March 29, 2023
File No. 19-062

**Subject: Response to Plan Review Comments
West Lot -Parcel 302405 9213
9167 SE 64th Street
Mercer Island, WA**

As requested, PanGEO prepared the following comments and discussions to address the geotechnical review comments from the City of Mercer Island. Our responses are as follows:

1a

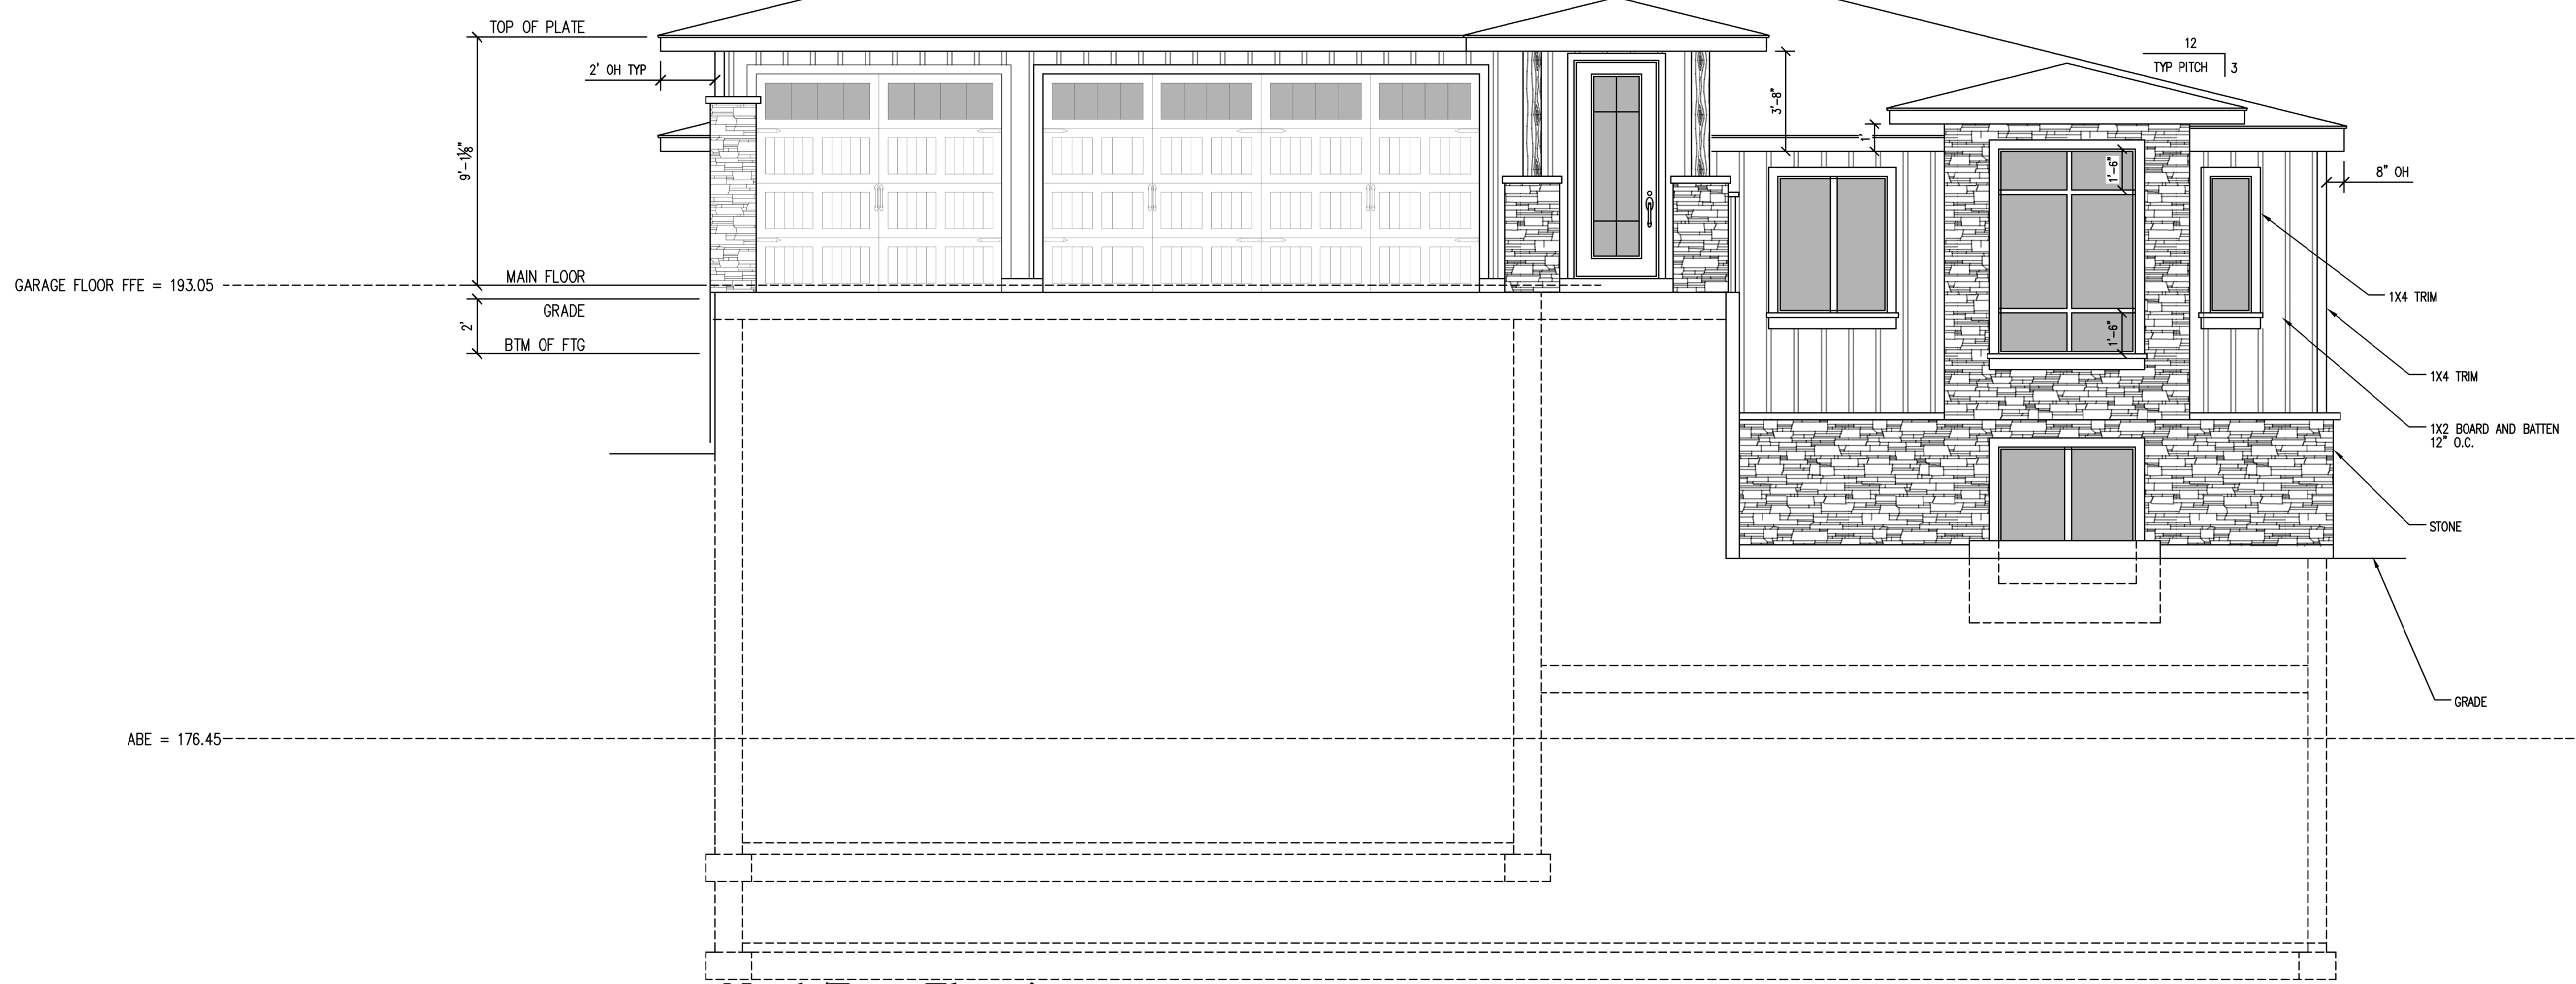
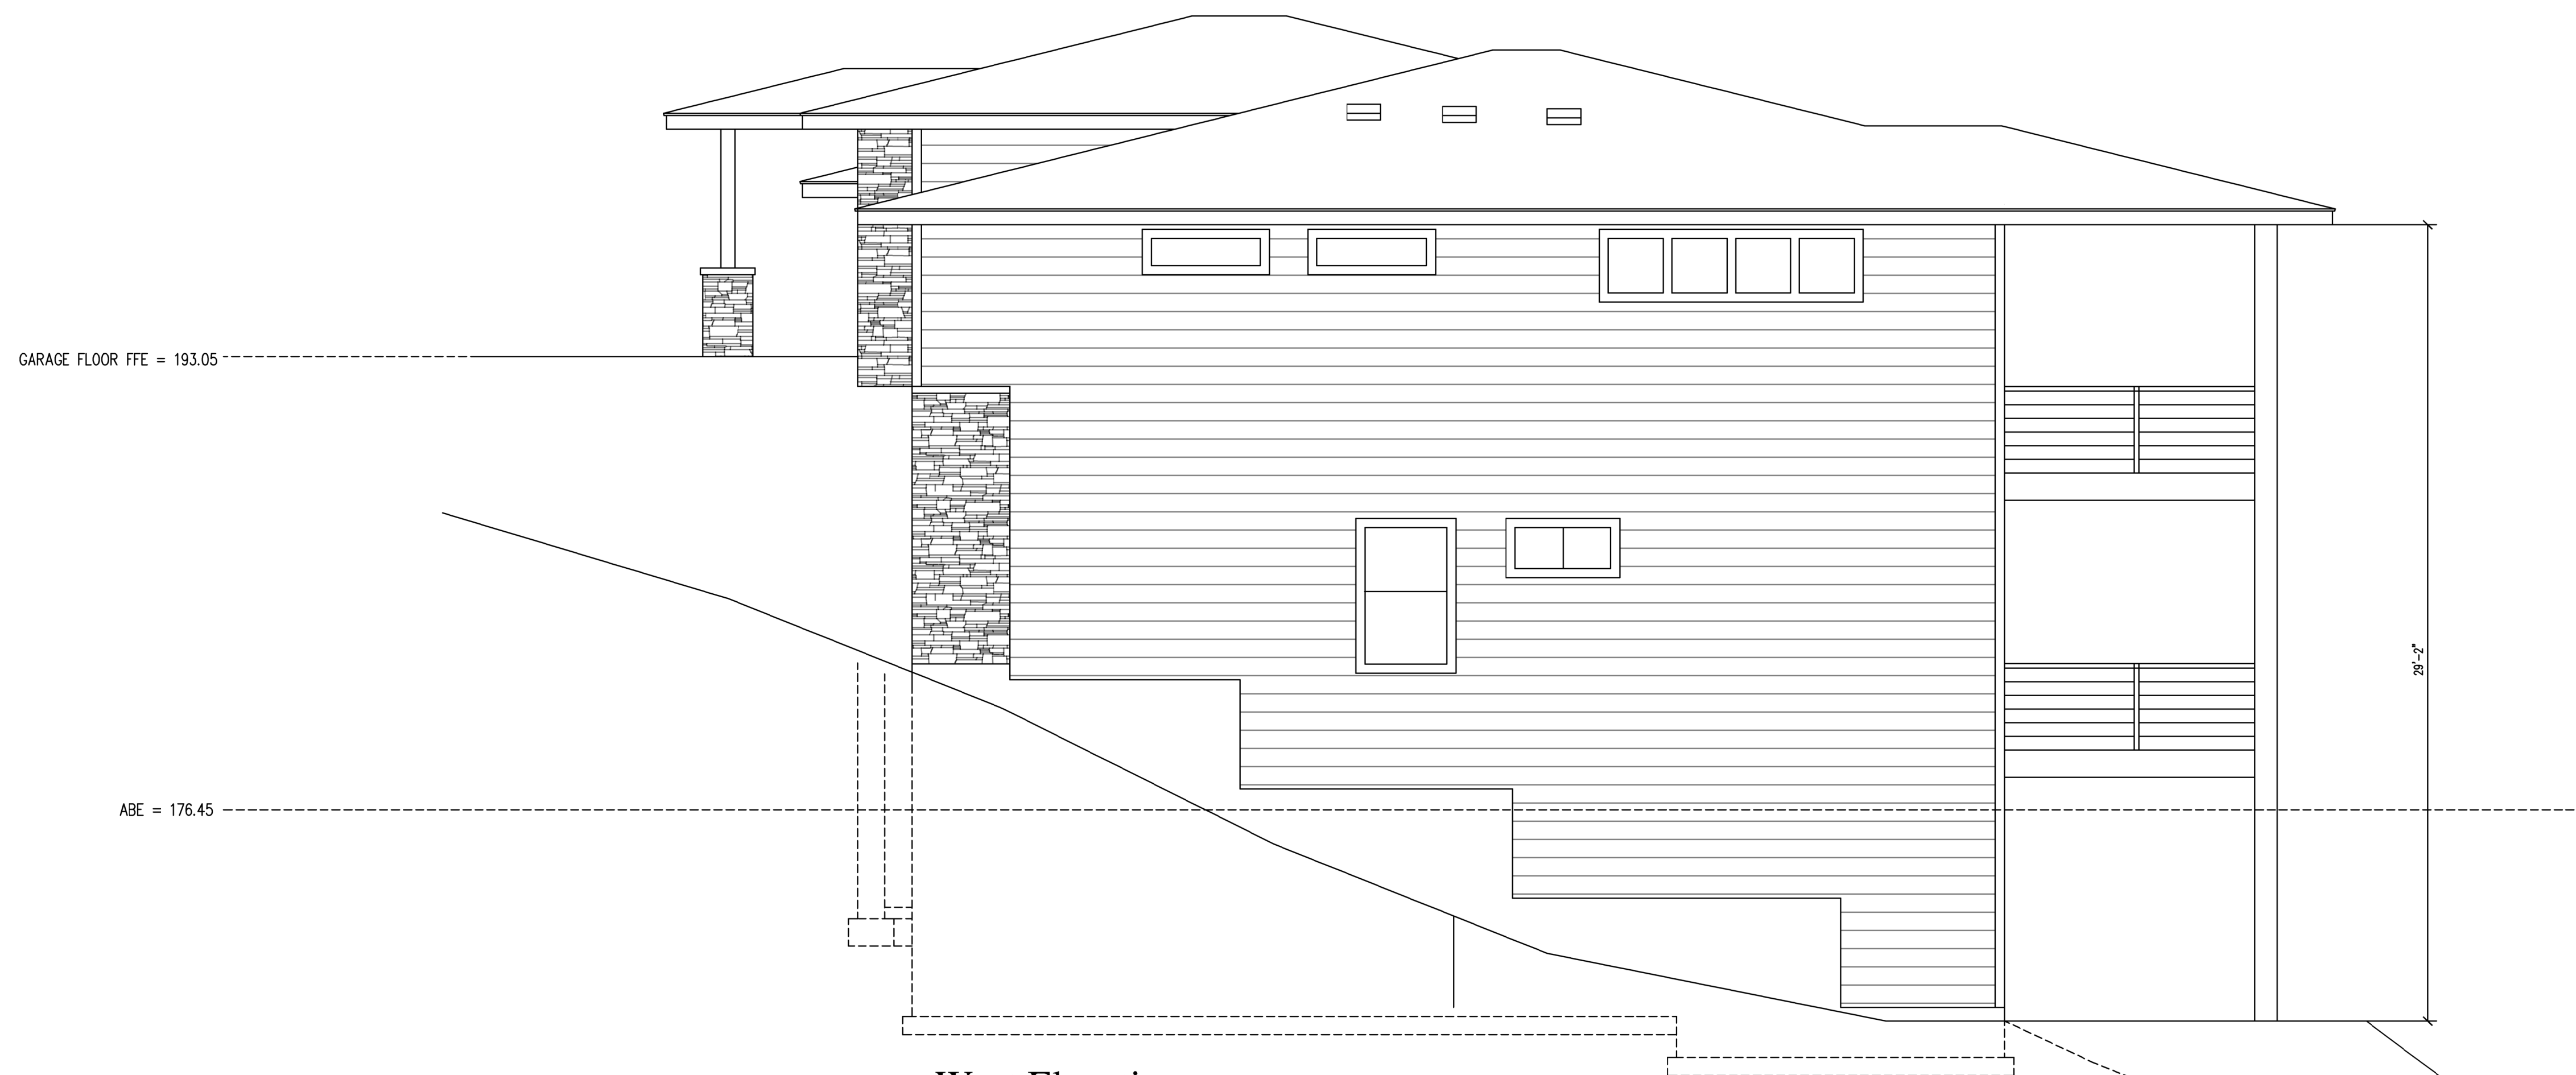
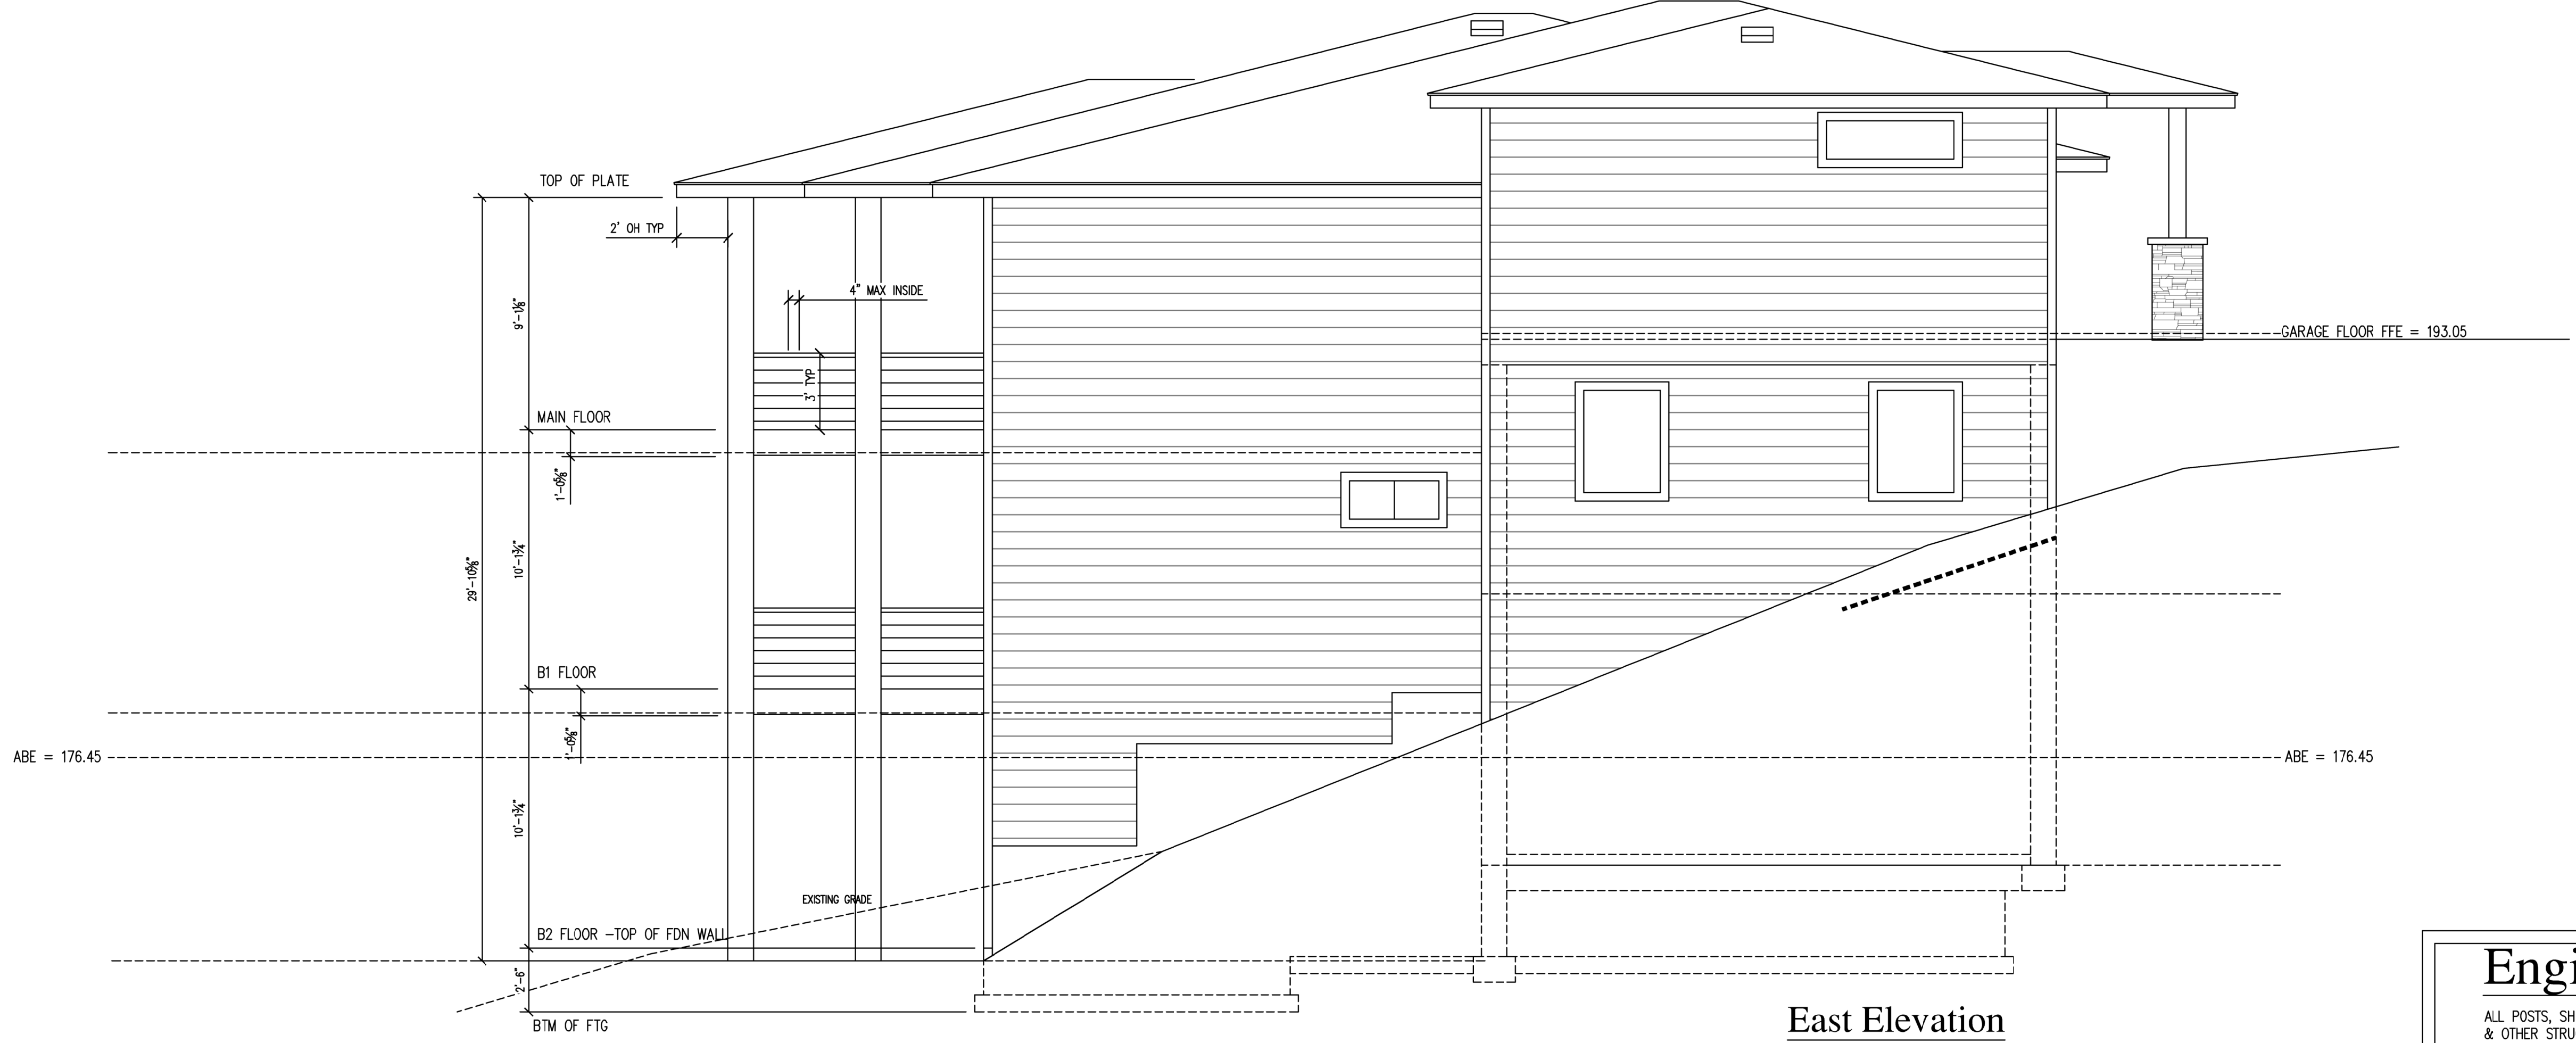
Sheet 1a – No permanent fill slopes may be graded steeper than 2H:1V, and this site may require flatter slopes or not be feasible at all, depending on our slope stability analysis.
